From: [REDACTED]
Sent: 28 August 2019 16:43
To: Planning.Responses <Planning.Responses@arun.gov.uk>
Subject: Environment Agency Response to: LU/159/19/PL

LPA ref: LU/159/19/PL

New maisonette over parking area, extend crossover & alterations to rear fenestration.

2 Croft Cottages, Pier Road, Littlehampton, BN17 5LS

Scale A1=1:50, A3=1:100 Drawn JHL Date 07/03/19										
19023-401										
C										
40m

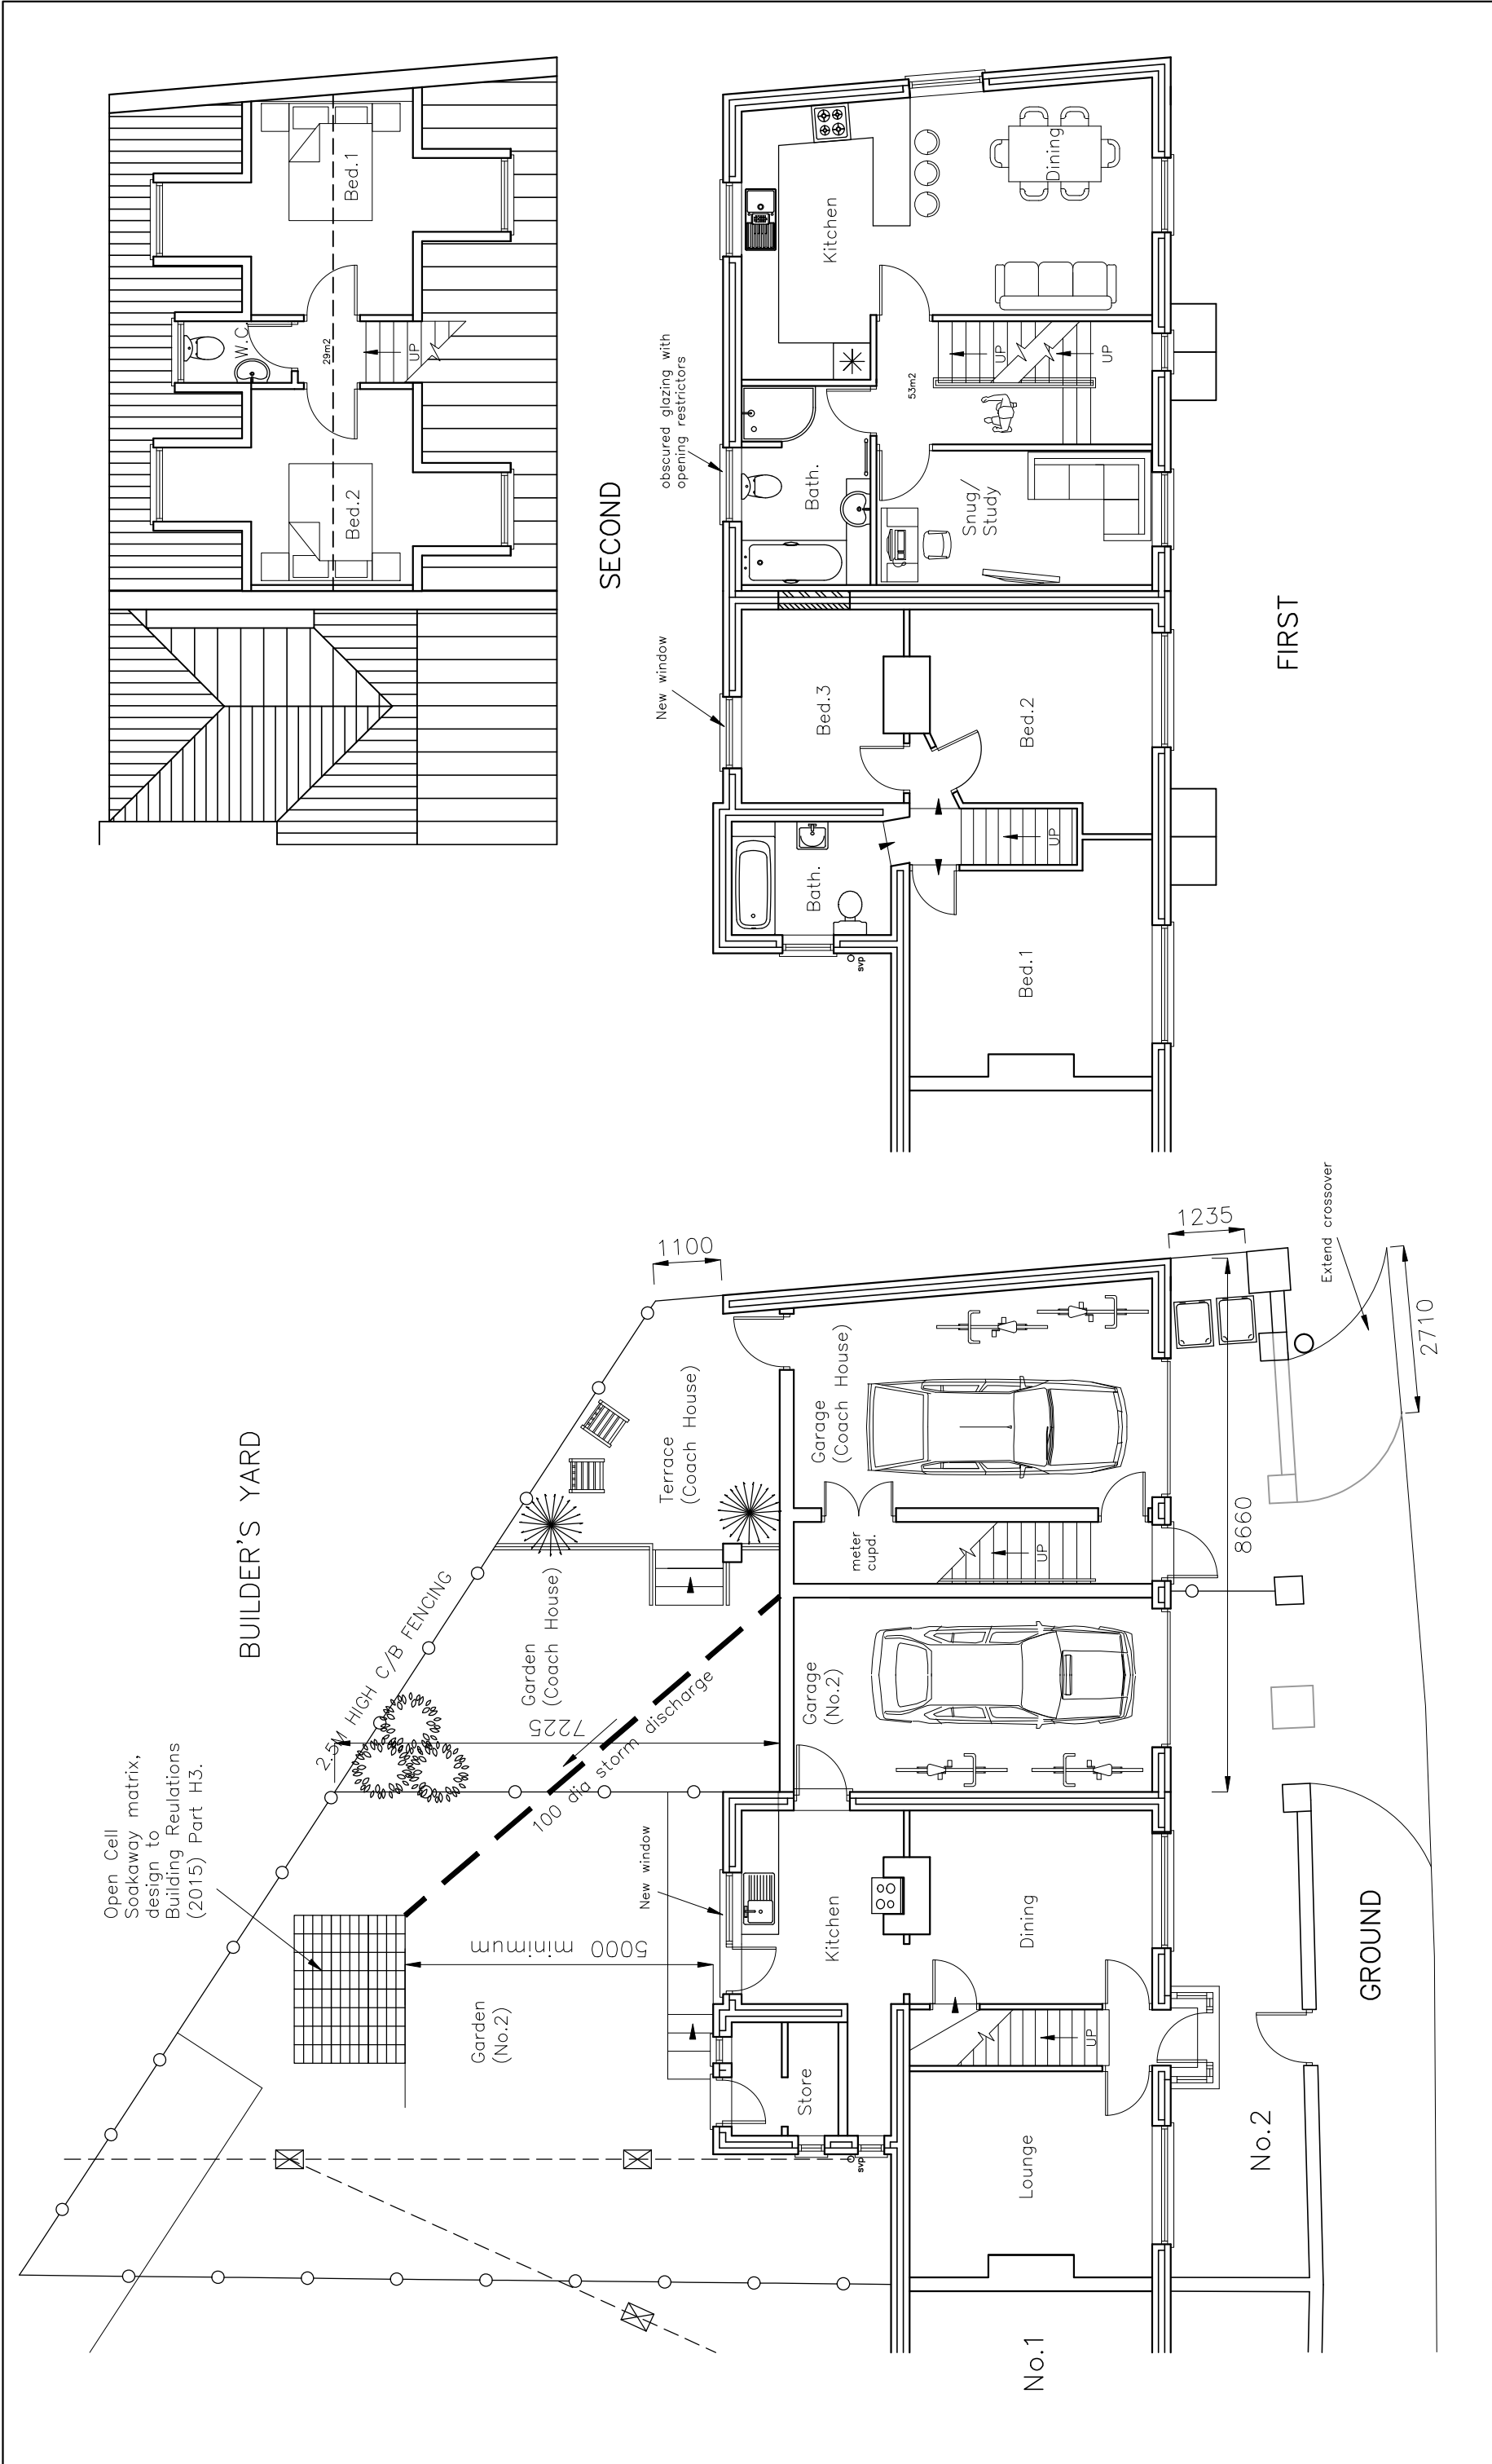
The development shall be carried out in accordance with the submitted Flood Risk Assessment (ref: Flood Risk Assessment (FRA) (April 2019) Critchley Architecture And Design Ltd) and the following mitigation measures it details:

- Sleeping accommodation is located on the first and second floors

These mitigation measures shall be fully implemented prior to occupation and subsequently in accordance with the scheme's timing/phasing arrangements. The measures detailed above shall be retained and maintained thereafter throughout the lifetime of the development.
